Re: Sketch Plat Submittal; Project #1010812; Lots 15A and 16A, Alvarado Gardens Unit 2

**Development Review Board (DRB)
Review Comments
Utility Development Section
Reviewer: Kristopher Cadena, P.E.
Phone: 505.289.3301**

**CITY OF ALBUQUERQUE
PLANNING DEPARTMENT
April 13, 2016
DRB Comments**

**DEVELOPMENT REVIEW BOARD
HYDROLOGY SECTION**

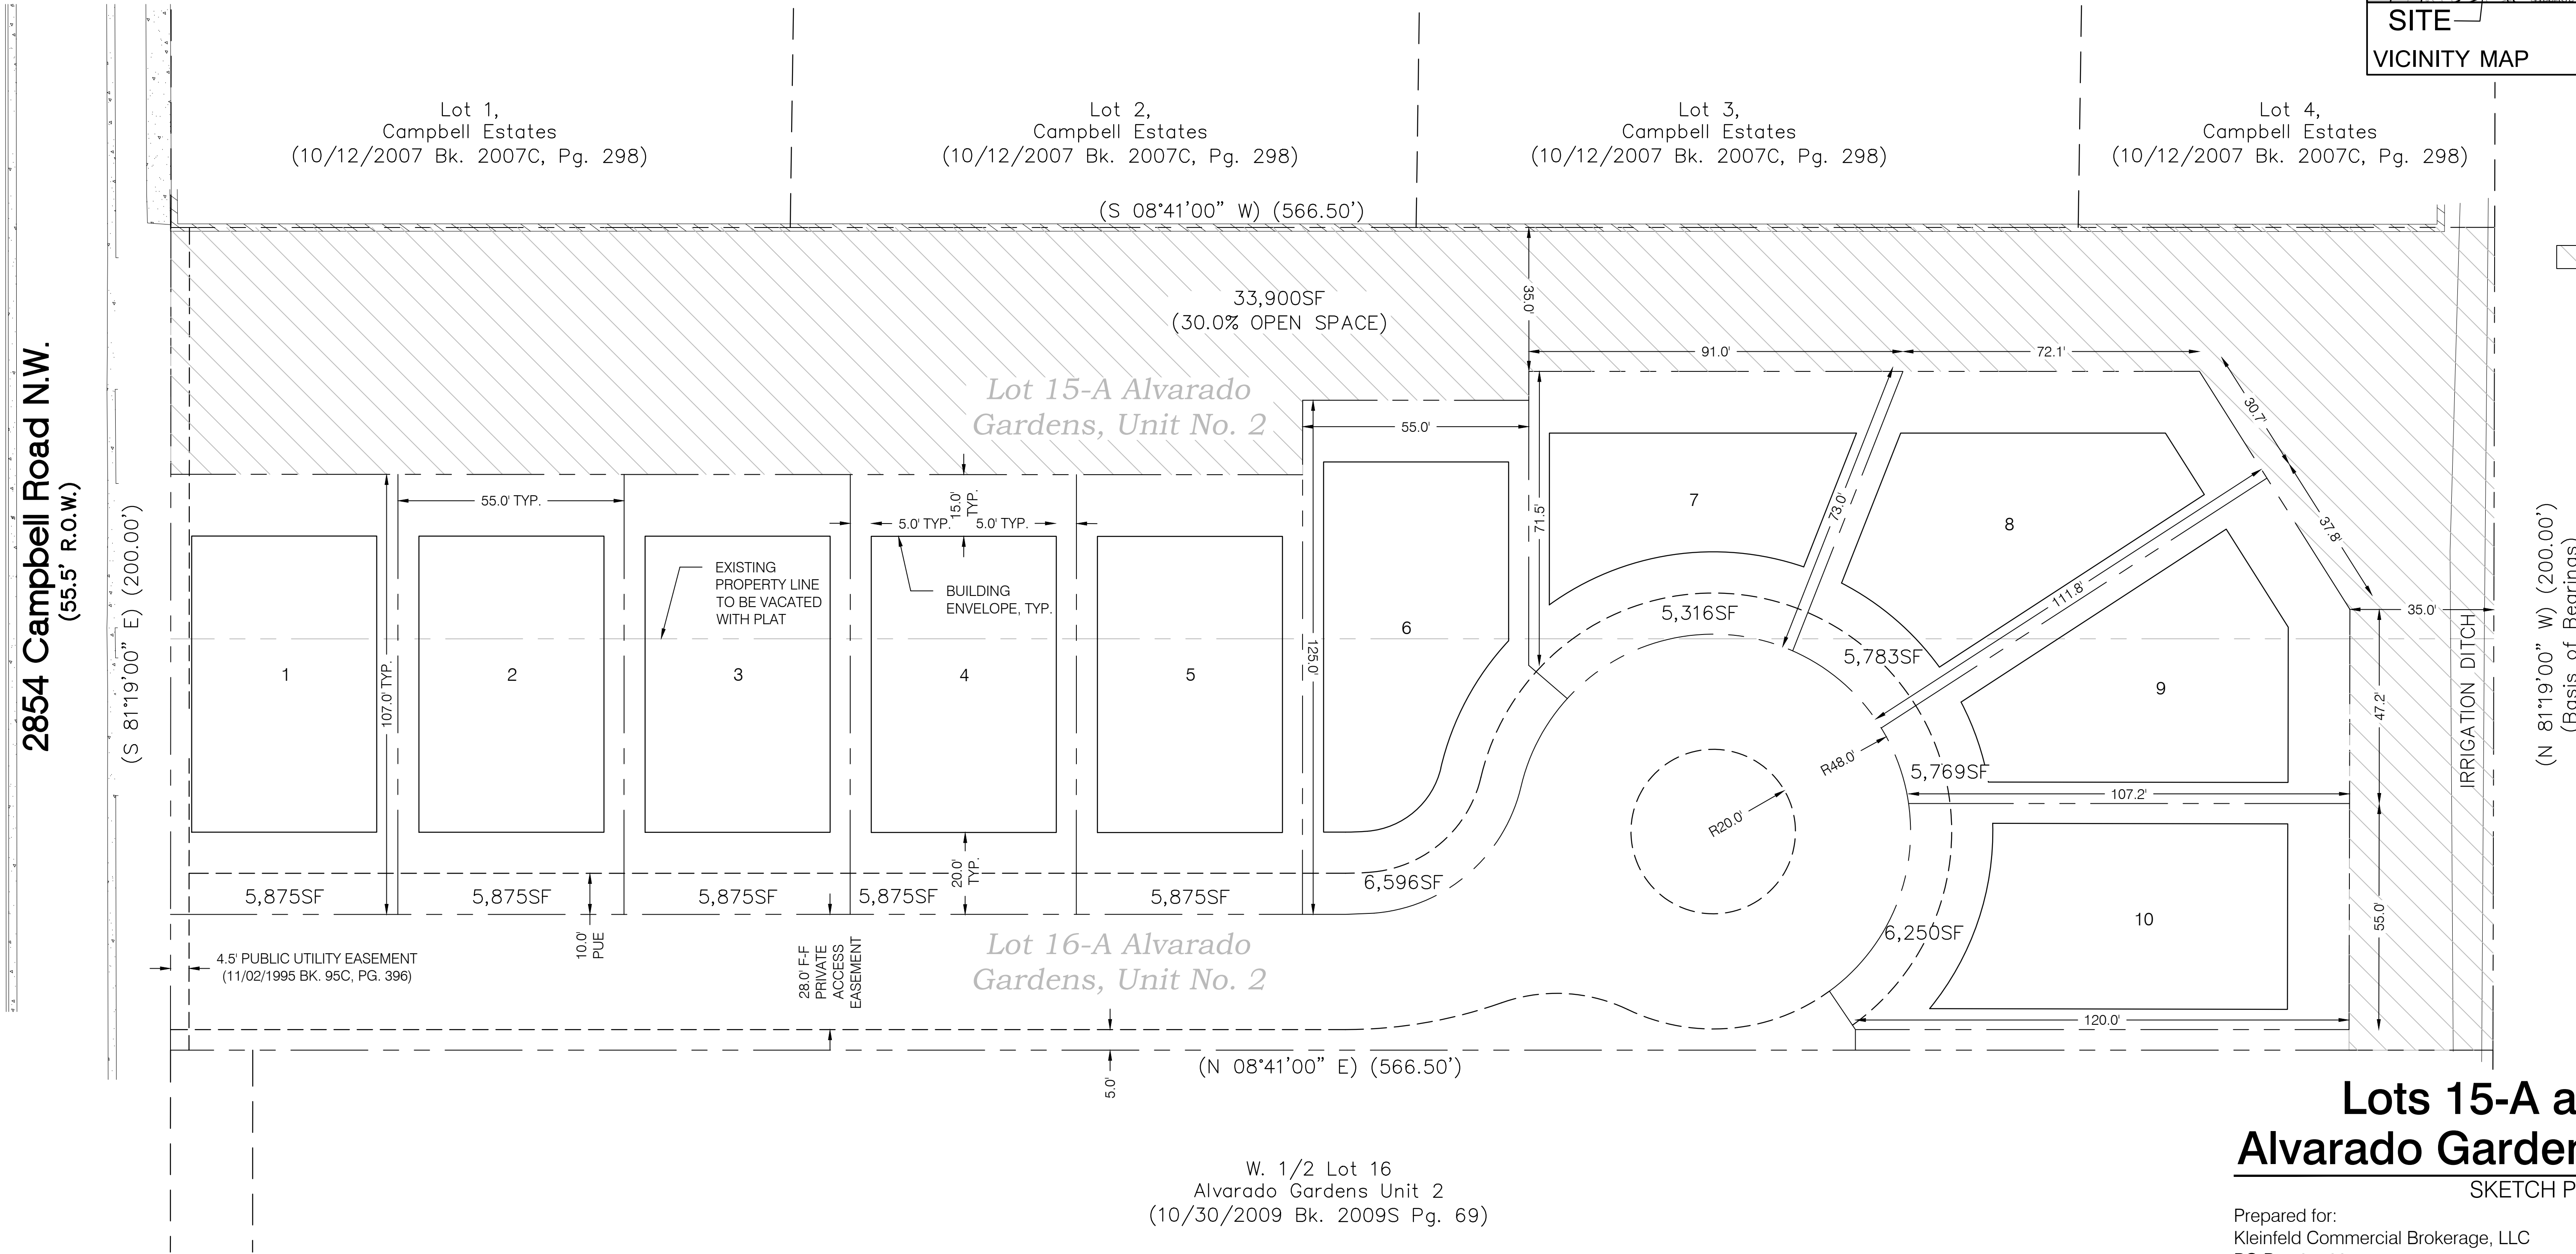
A request for Sidewalk Waiver on the east side of the proposed street could be appropriate; refer to comments from Transportation Development regarding waiver and proposed right of way. If a waiver is deemed appropriate, then a request for a Subdivision Design Variance to reduce the R-O-W by 4 feet would also be appropriate.

- An approved Drainage Report, Grading Plan, and Infrastructure List are required for Preliminary Plat / Site Plan approval.
- Development in the Valley: Discharge is limited to 2.75cfs/acre or retain the first ½" of runoff.

1. Provide an exhibit showing the location and width of sidewalk and defining the distance from back of curb to the property line. Right of way dedication may be required.
2. For final plat, any access easements need to be shown with all beneficiaries and maintenance responsibilities listed.

Cal de Sac - 45' R FM require 90' diameter.

The layout features a 28-foot private roadway easement with a 48-foot radius cul-de-sac that is primarily a single loaded street. It is assumed that a sidewalk waiver will be requested for the west side of the street, as well as a request for a Subdivision Design Variance for the private roadway easement width. A sidewalk on the east side of the property will be provided within the 10-foot public utility easement.
